NORTH FALLS OFFSHORE WIND FARM

Appendix E7 to the Natural England Deadline 7 Submission
Natural England's Marine Mammal Advice on the Applicant's Deadline 6 Documents

Planning Inspectorate Reference EN010119

15 July 2025

Plate 1.2 Proposed piling mitigation procedures.

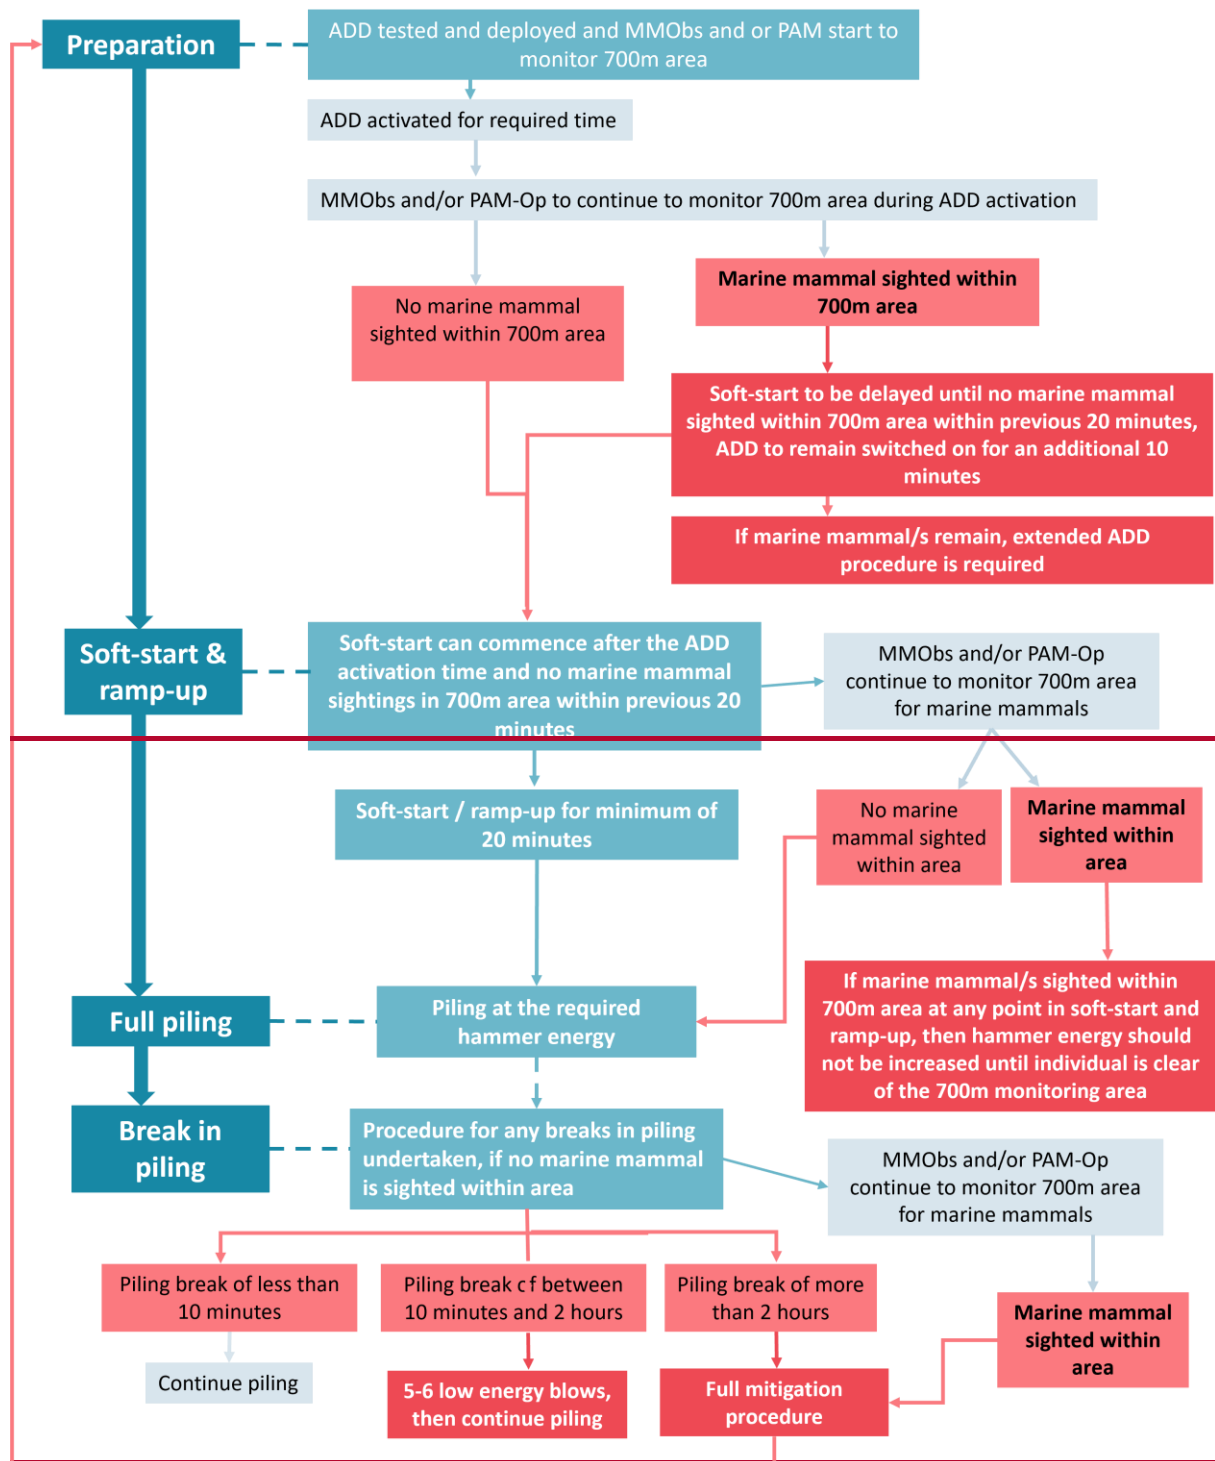
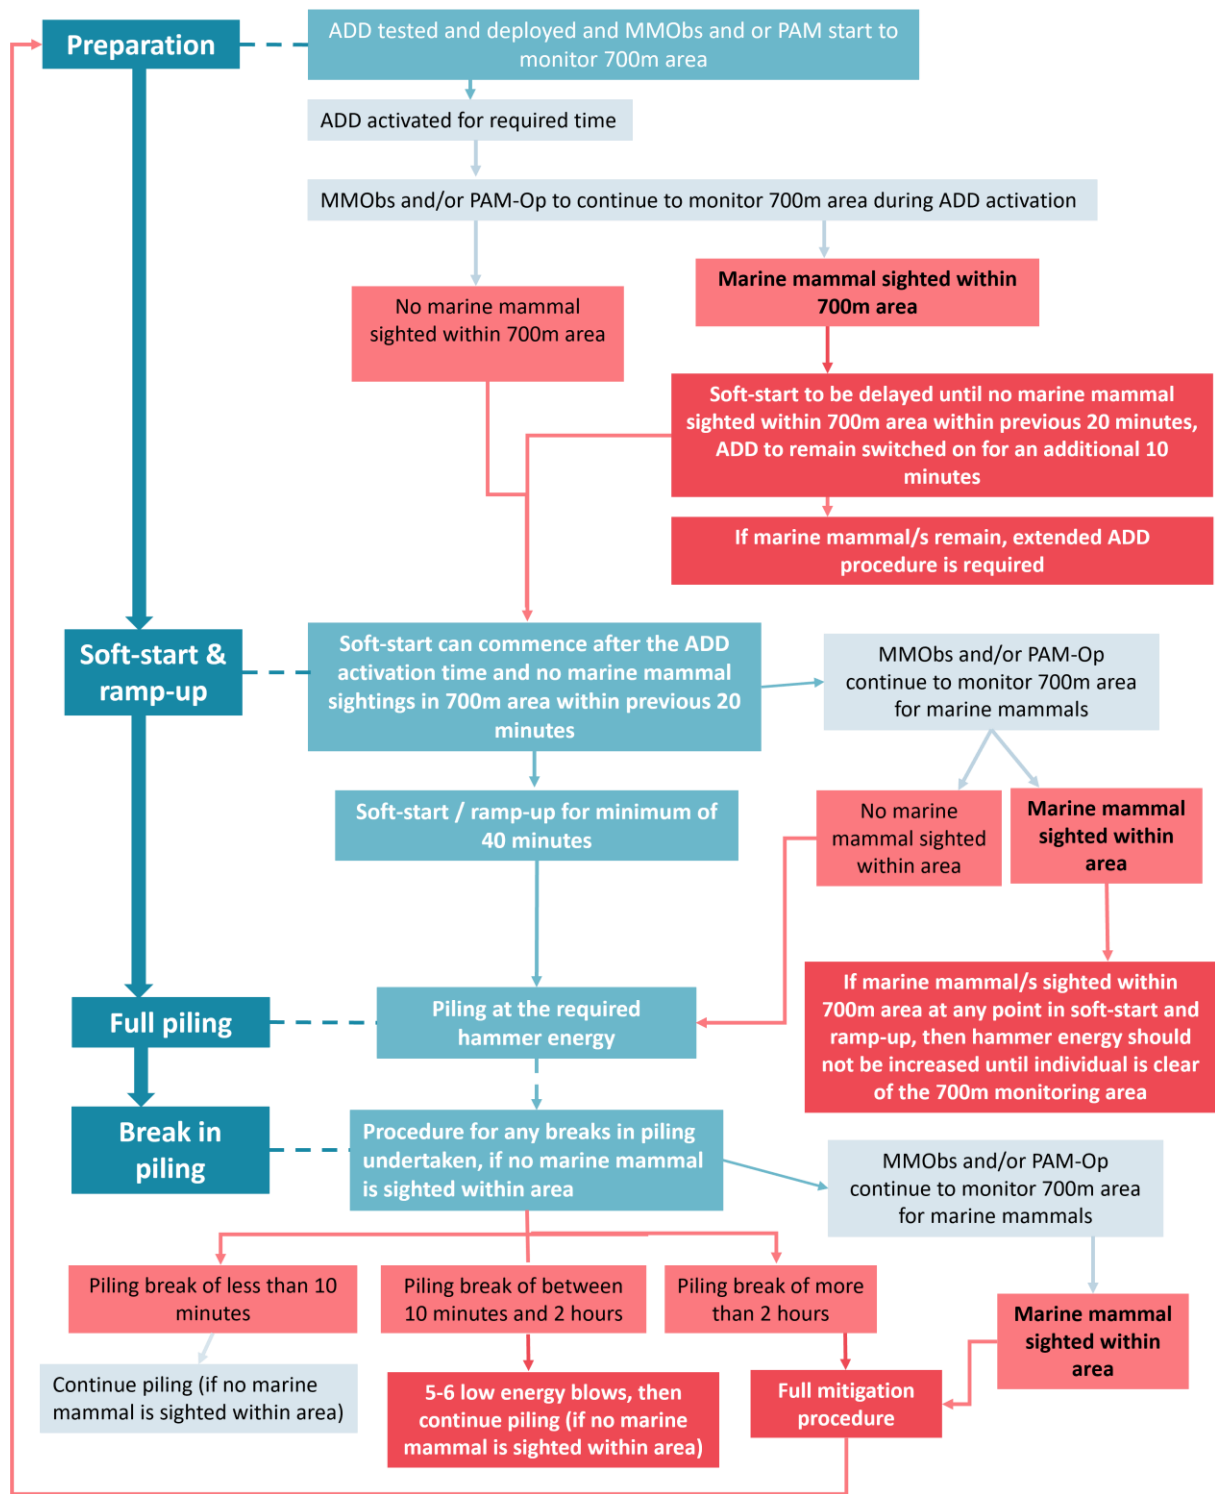
Document reviewed: [REP6-030] 7.7 Draft Marine Mammal Mitigation Protocol (Rev 3) (Tracked)			
NE Ref	Section	Key Concern and/or Update	Natural England's Advice to Resolve Issue
1	Plate 1.2	We are content with the amendments of the Plate 1.2 as per our advice.	N/A
2	Section 1.4 & Table 1.5	Natural England notes that the Applicant has not accepted our advice on the use of Passive Acoustic Monitoring (PAM) for Unexploded Ordnance (UXO) clearance. The Marine Mammal Mitigation Protocol (MMMP) [REP6-030] still refers to this as 'unlikely to be required'. We also note the Applicant's response in E27 of Table 1.5 Examination Comments and Relevant Representations: <i>"For UXO clearance the Applicant has committed to the use of PAM in instances when there are not favourable conditions with good visibility (sea state 3 or less)."</i>	Our advice remains that PAM is a required monitoring tool for UXO clearance especially given that the proposed development is within a designated SAC for harbour porpoise. Therefore, we do not consider this issue to be resolved.
